PCD Project Number: PPR2232 & MS232 Unresolved.s

DRAWN BY: O.E. WATTS DATE: 1-29-21 DWG. NO.: 20-5523-05 SURVEYED BY: DEV, ESW, 10-6-20	APPROVED BY: PROJ. NO. DWG.	REVISIONS	PROJECT OLIVER E. WATTS CONSULTING ENGINEER COLORADO SPRINGS FALCON STORAGE PARCEL PART W 1/2 SEC. 1, T.13S., R.65W., 6TH P.M. EL PASO COUNTY	SHEET NO. GRADING AND EROSION CONTROL PLAN 2 OF 4	SHEET NO.
---	-----------------------------------	-----------	---	---	-----------

1"=40'  
INTERIM CONDITION DURING CONSTRUCTION TO BE CONVERTED TO SAND FILTER BASIN

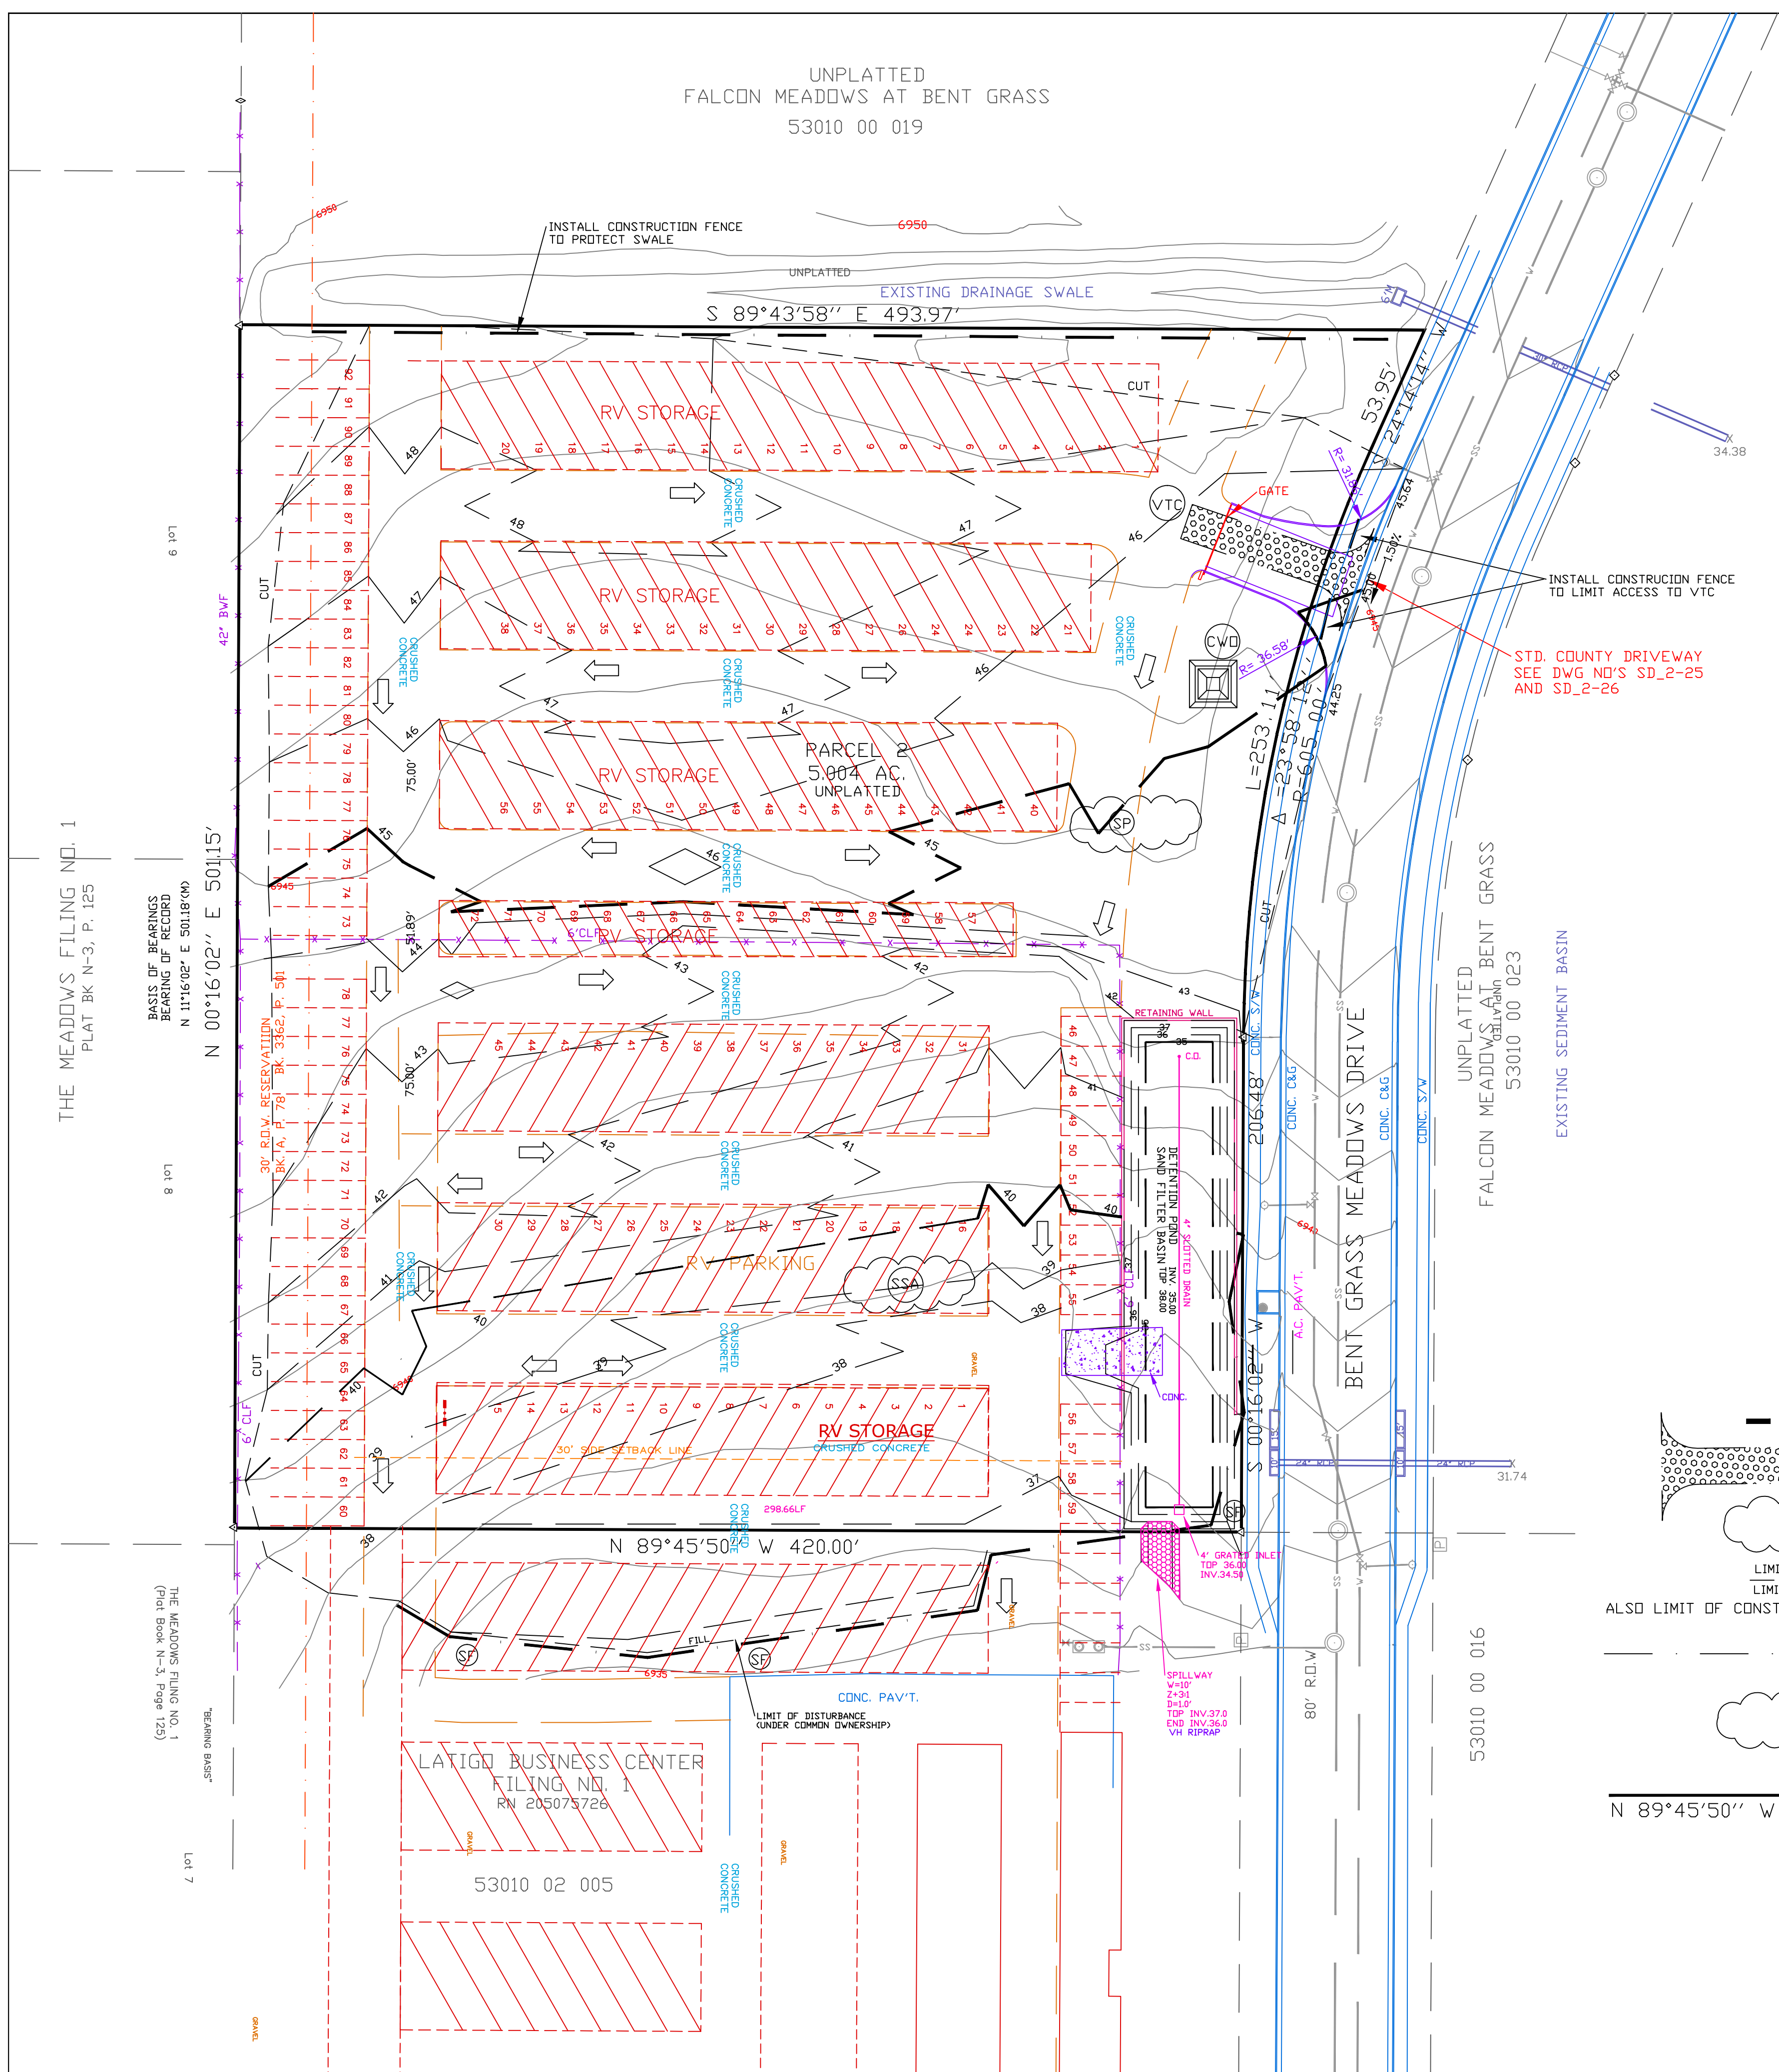
show existing detention basin where flows are being routed to. SWMP states: This project outfalls to an existing detention pond, Falcon Meadows on the south side of Woodmen Road, owned and operated by another entity?

remove red linework as it clutters the plan. Add back the gray outline of the parking areas and identify the surface material for the RV parking spots, if different from the drives

Clearly label existing contours. unresolved

existing/proposed? to remain? to be removed? unresolved.

The details listed do not match the proposed driveway shown on the plans. It appears that a cross pan is proposed. Please provide the appropriate detail and identify the width of the cross pan. Please revise accordingly.

Please label and provide detail of the proposed PED ramps on each side of the driveway. Identify the cross slope at the pedestrian path at the driveway (2%max)

are you proposing a retaining wall here? provide details

show sidewalk slopes and dimensions of pond

identify the location of the maintenance access to the sand filter basin bottom

call out as TSB, to be converted to a SFB.

i assume this is a concrete rundown. Please provide specifications for this and label it on the plans.

where is flow outfalling?

adjust C/F line to match legend

Please see comments on the drainage report regarding the conveyance of flow from the sub-basins to the pond and revise the plan accordingly. Provide spot elevations as needed to show how flow is directed to the pond.

flow arrows do not match the contours. Revise

Provide energy dissipation at all inlet points into the sand filter (and calcs in drainage report). Use an impact basin for pipes and a baffle chute or grouted sloping riprap drop if a channel or swale is used, or install a Type VL or L riprap basin underlain with geotextile fabric at the inlet. Fill all rock voids with the filter material specified in Table SF-1.

Final stabilization needs to be shown on figure. Consider creating a separate sheet to show all areas for proposed asphalt, proposed concrete, and proposed seeding/mulching. Unresolved.

Per DCMv2 Section 4.3, outlet pipe should be 18" minimum. (UD Figure 6-a). An 18" pipe will not fit within this outlet box. revise accordingly.

Limits of disturbance is not the same as the cut/fill line. Adjust accordingly. Unresolved.

TSBs collect water in pond and discharge to outfall. adjust drain pipe accordingly

is this for the temporary sediment basin? Provide details of temporary sediment basin including riser pipe diameter and perforation sizing, number of rows of holes, required volume, location of outlet pipe and spillway, and tributary area to the sediment basin. And provide contours for sediment basin.

Provide construction details for SFB. Including elevations, WQCV/EURV/100YR elevations, pipe length and elevation, orifice hole sizes and elevations, detail for outlet structure pipe penetration (including location, slope, and elevations), spillway details (including elevations, storm elevations, material, riprap gradation, slopes), clean out, concrete rundown details, filter material, etc etc.
